Erection of a first floor front/side extension, two front and two rear dormers to facilitate a loft conversion.

Amendments Summary

To Luton Council
Planning department
Your ref: FZAFFA/24/00158/FULHH

Designer(s) accept no responsibility for any costs, losses, claims however arising from these drawings, specifications and related documents unless there is full compliance with the client and any authorised user of the following:

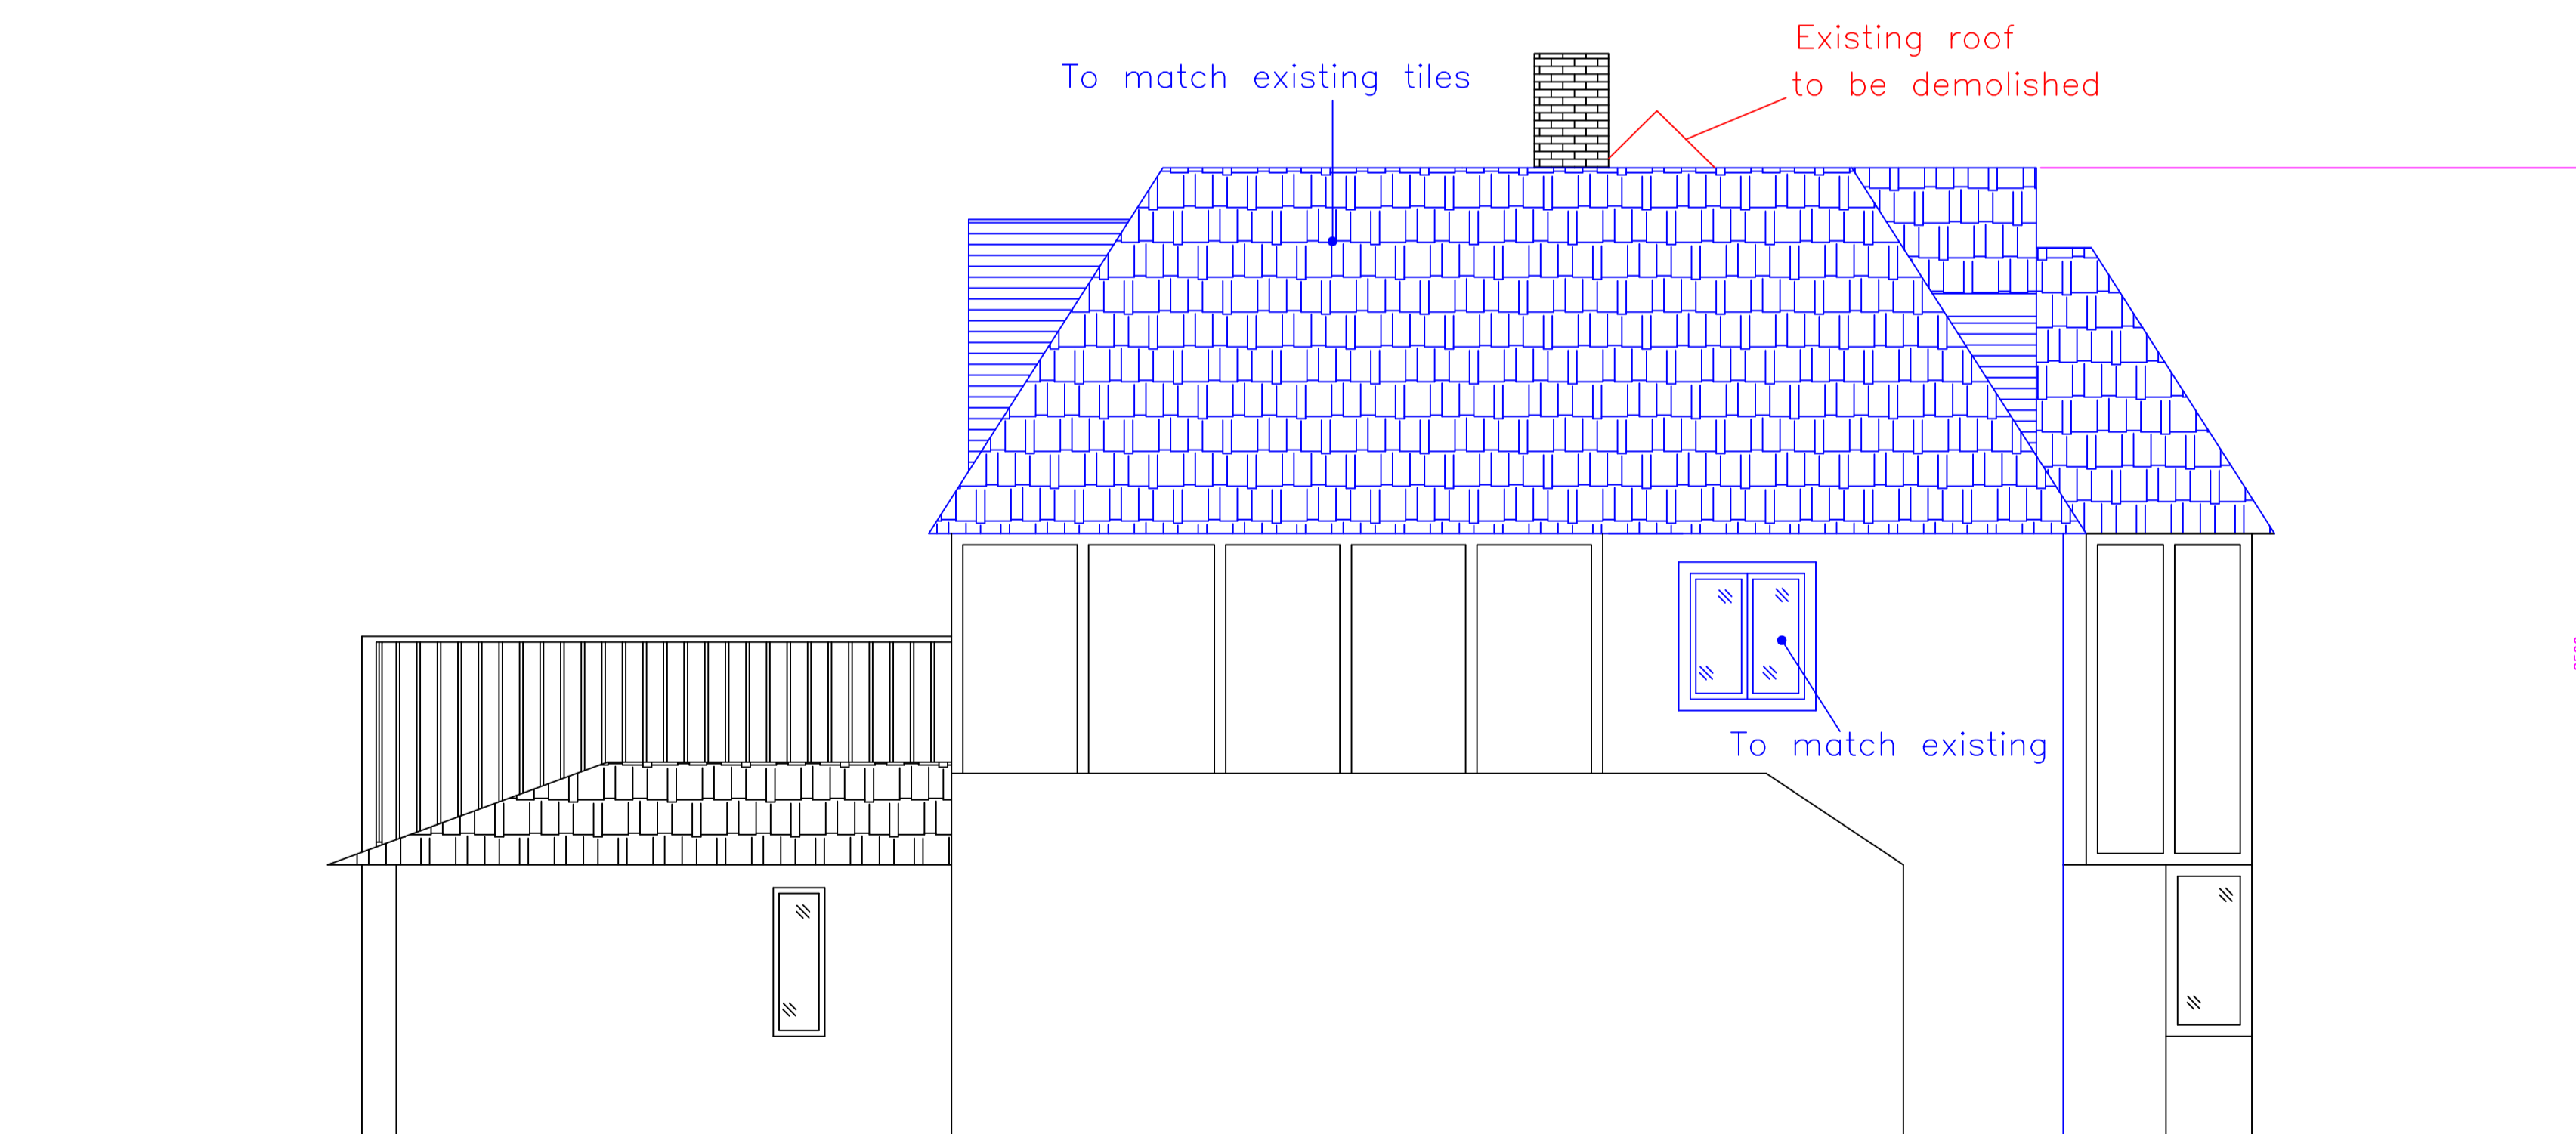
2) Please supply full external height dimensions of the first floor extension and full external dimensions of the front and rear dormers.

New drawings supplied with dimensions.

# PROPOSED FIRST FLOOR PLAN

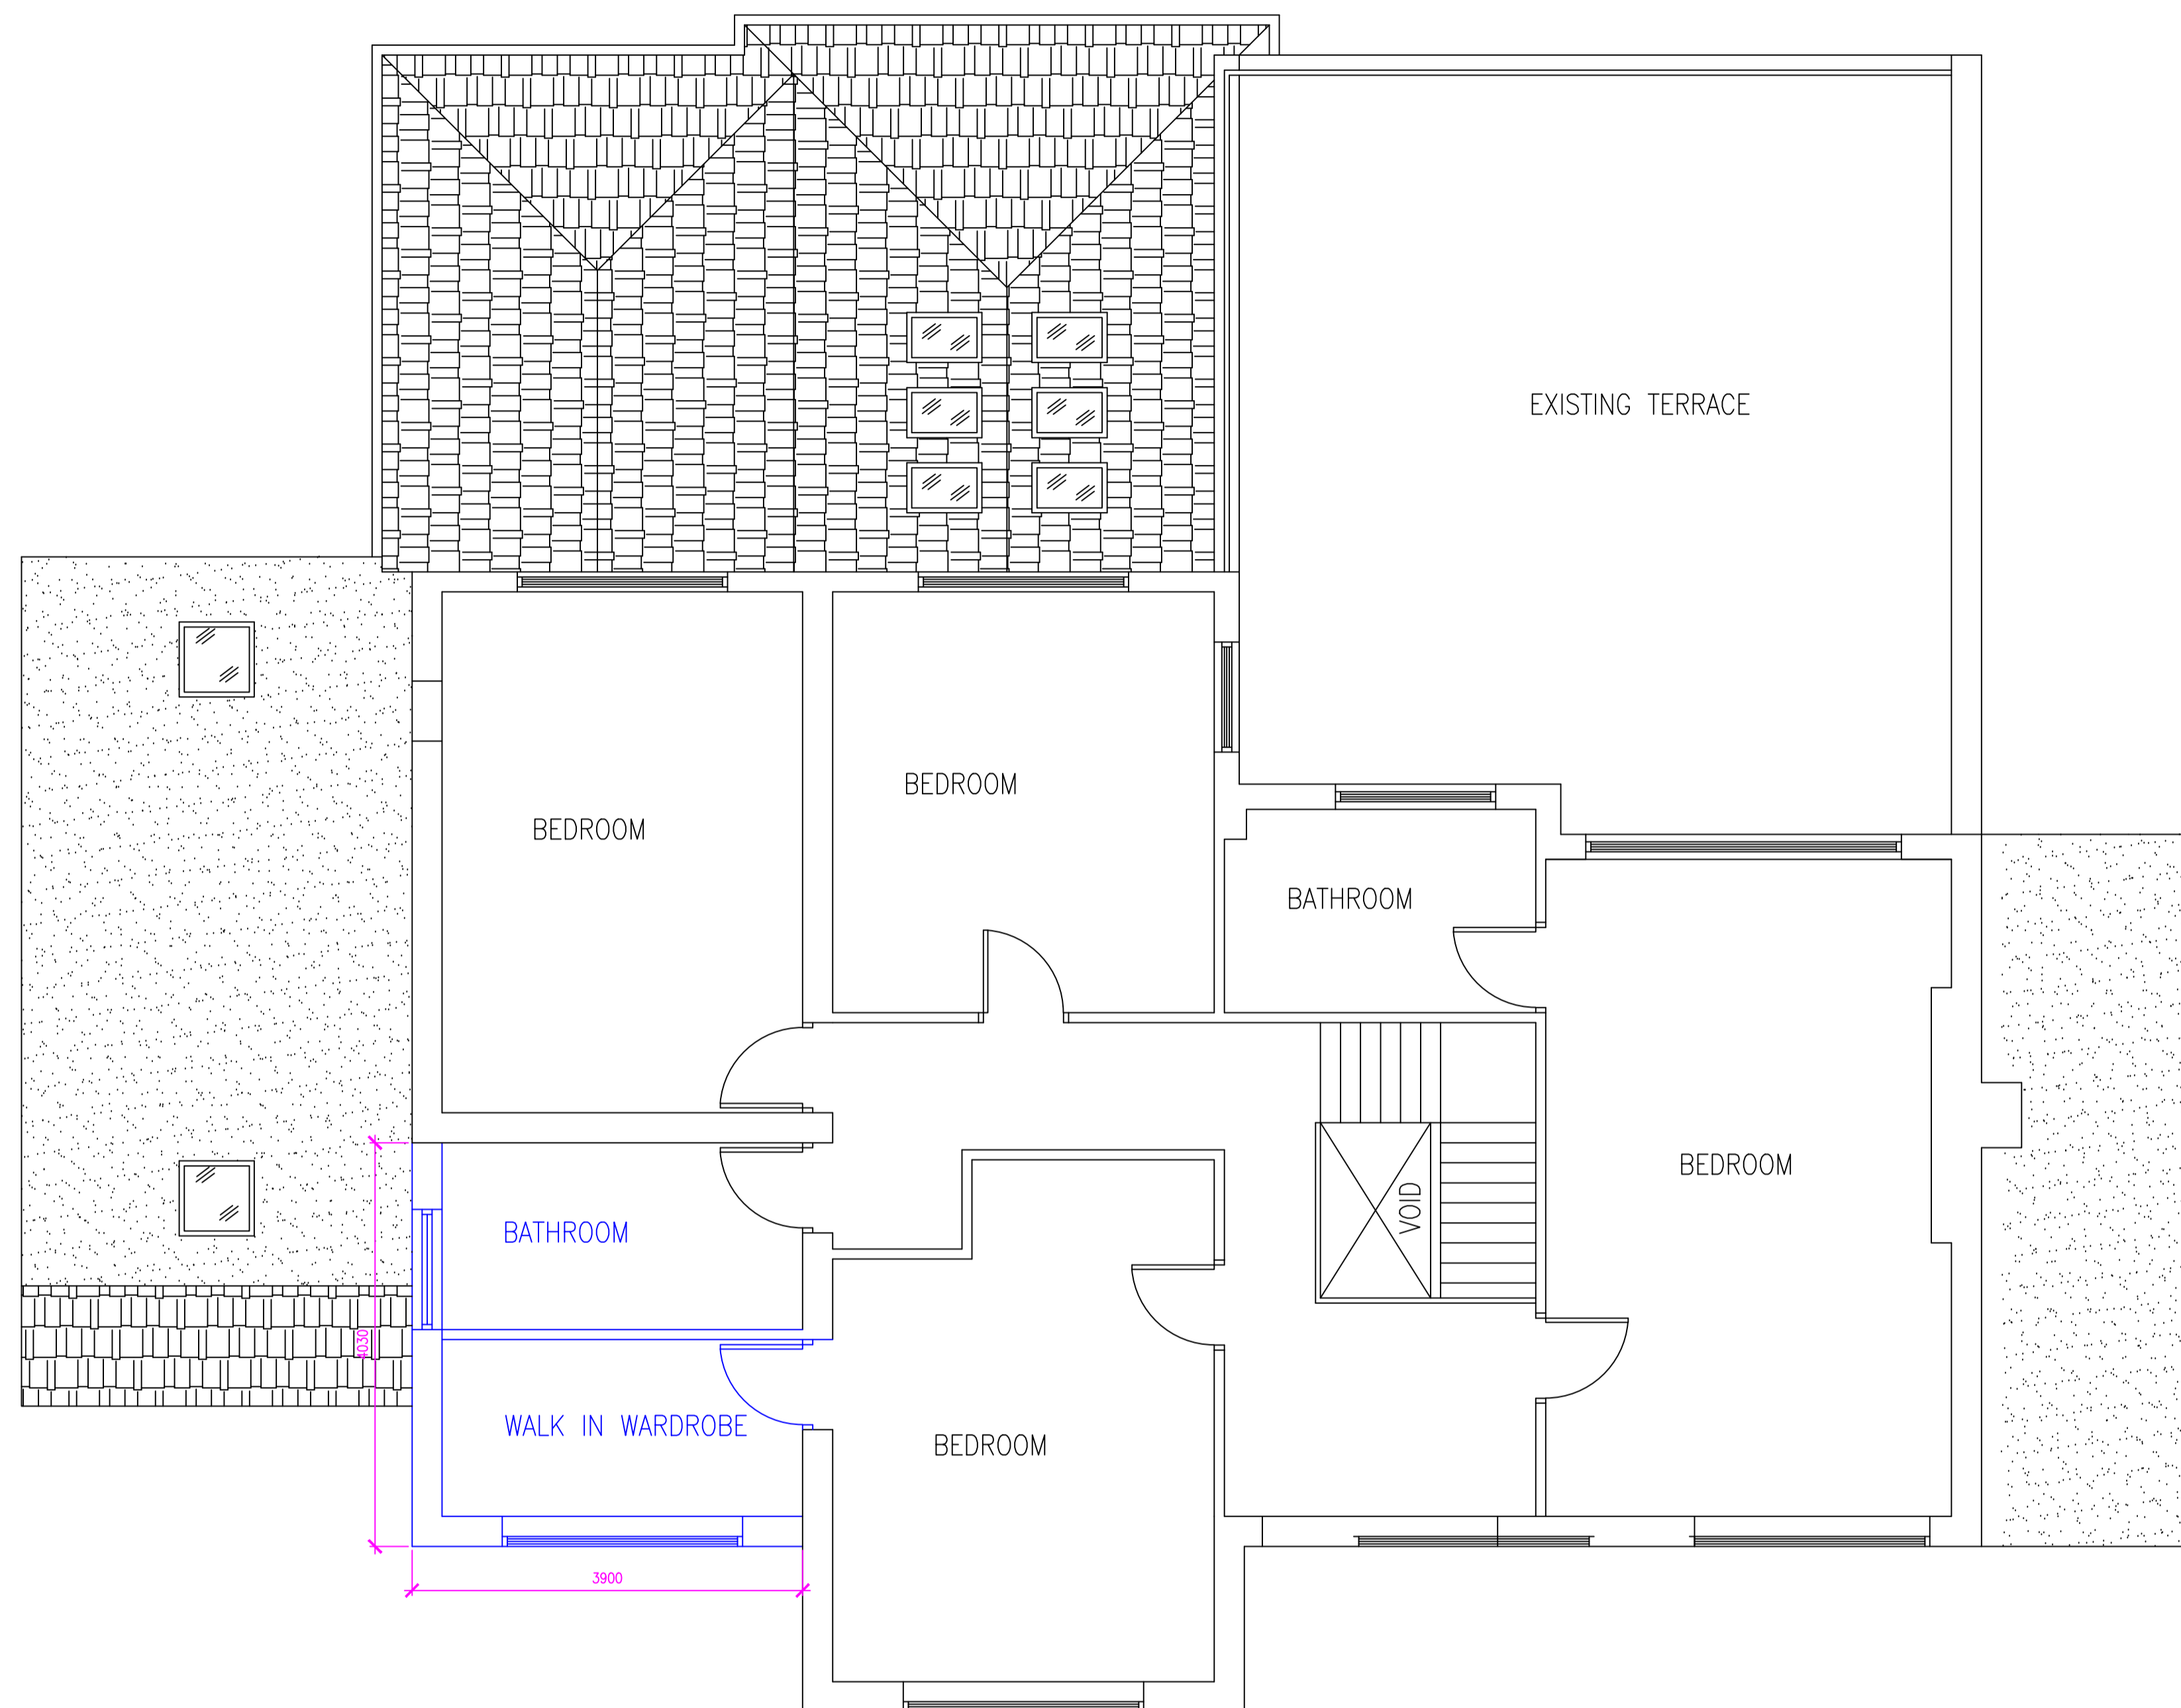
3) Please supply floor plans to show dimensions of first floor extension. Scale 1:100 or 1:50

Proposed first floor plan provided with dimensions

Drawing Name:
Location & Block Plan

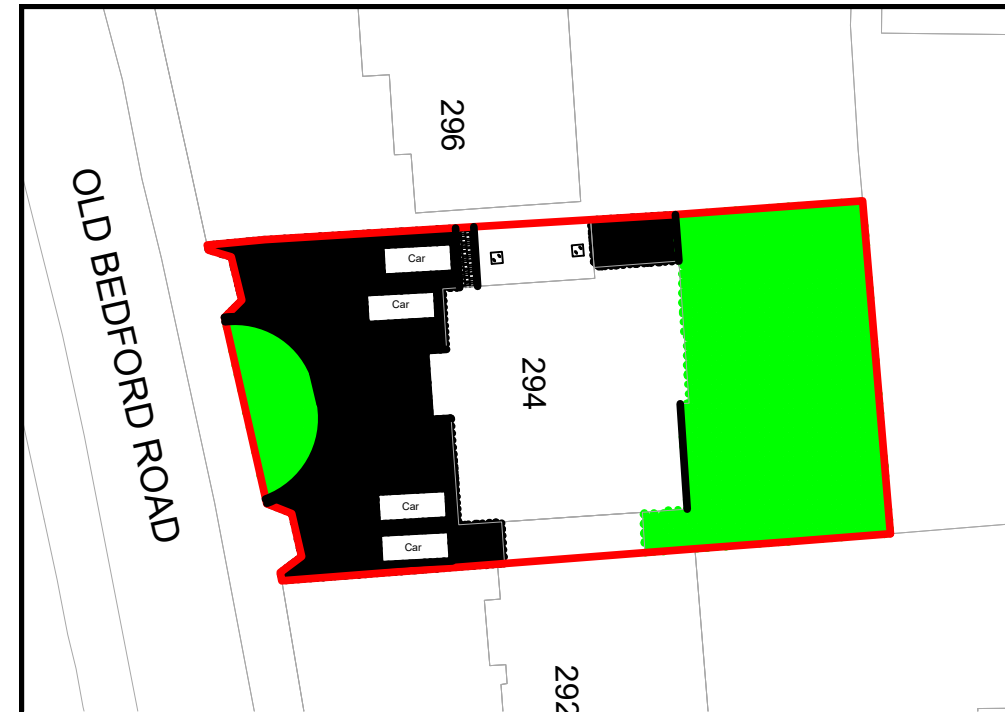
1) Please supply a parking plan

4) Please supply a block plan. Scale 1:200 or 1:500

Parking plan is now provided

Block plan in scale of 1:500 provided.
